From: Juan Baeza
Sent: 20 July 2017 10:43
To: 'Estella Wood'
Cc: Mark Jones; Nicola Spencer
Subject: RE: AB/71/77/HH - 20 Howard Road, Arundel

From: Estella Wood [REDACTED]
Sent: 19 July 2017 16:24
To: Mark Jones
Cc: Juan Baeza
Subject: AB/71/77/HH - 20 Howard Road, Arundel

3. 4 The windows at **first floor** and second floor level in the west elevation of the building facing No.22 Howard Road shall at all times be fixed shut below 1.7m from the floor level of the room in which they are installed and remain glazed entirely with obscure glass.

WEST ELEVATION

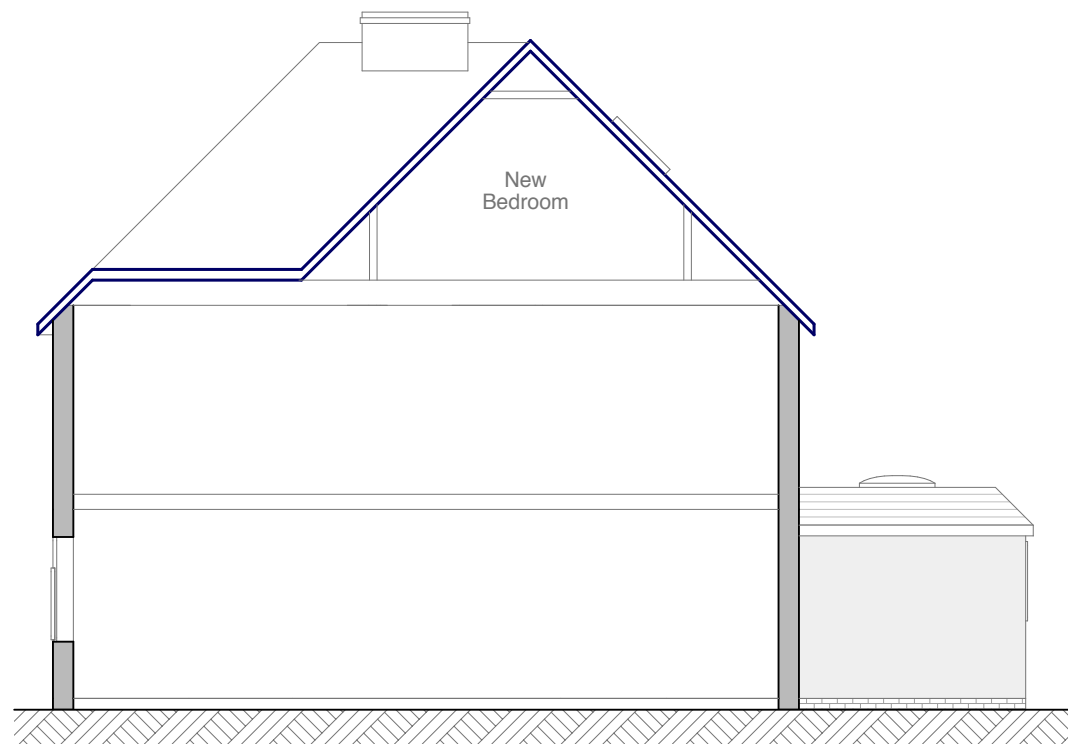
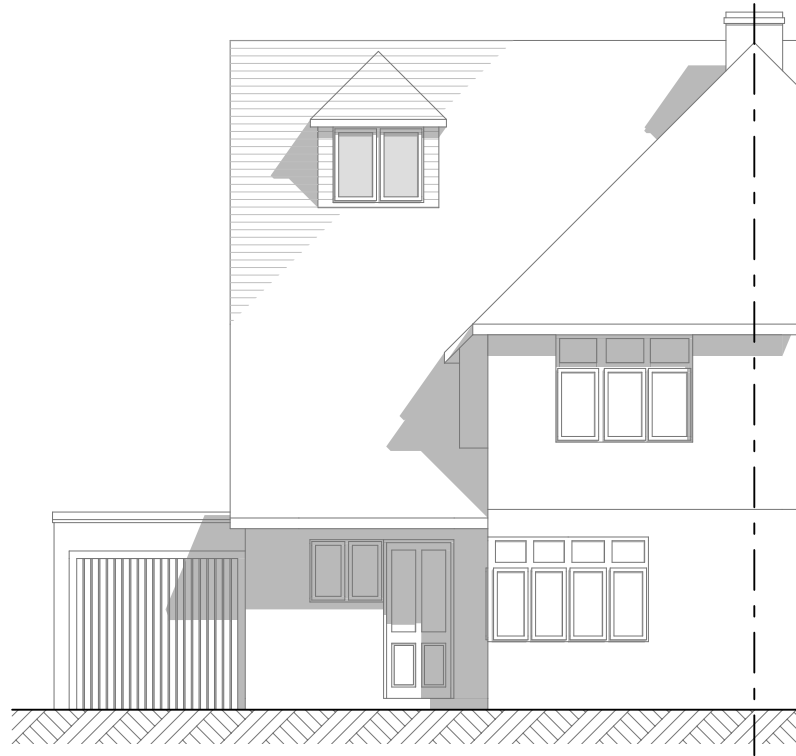
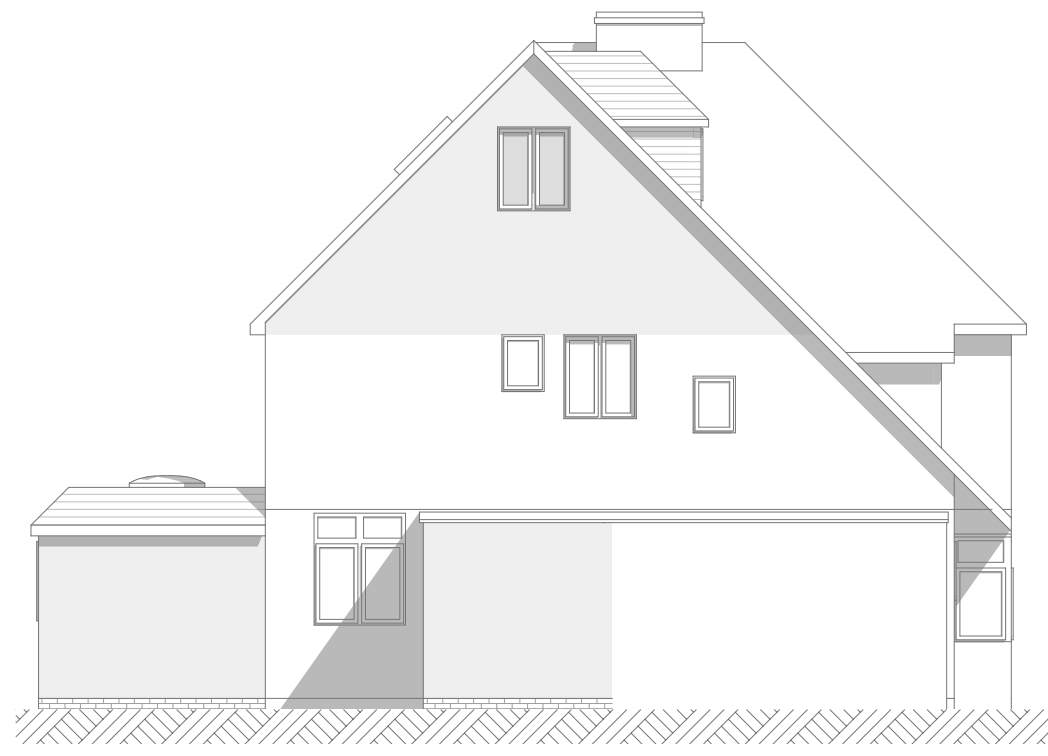
Please could I refer you to condition no.4 of the above Approval. There are no new windows on the first floor as part of this application. Could you therefore please remove this part of the condition and reissue the Approval?

Please accept my apologies for thinking these were new windows when in fact they are existing windows. Reference to the first floor will be deleted and a new corrected decision will be issued shortly. I'll notify you when this has been done.
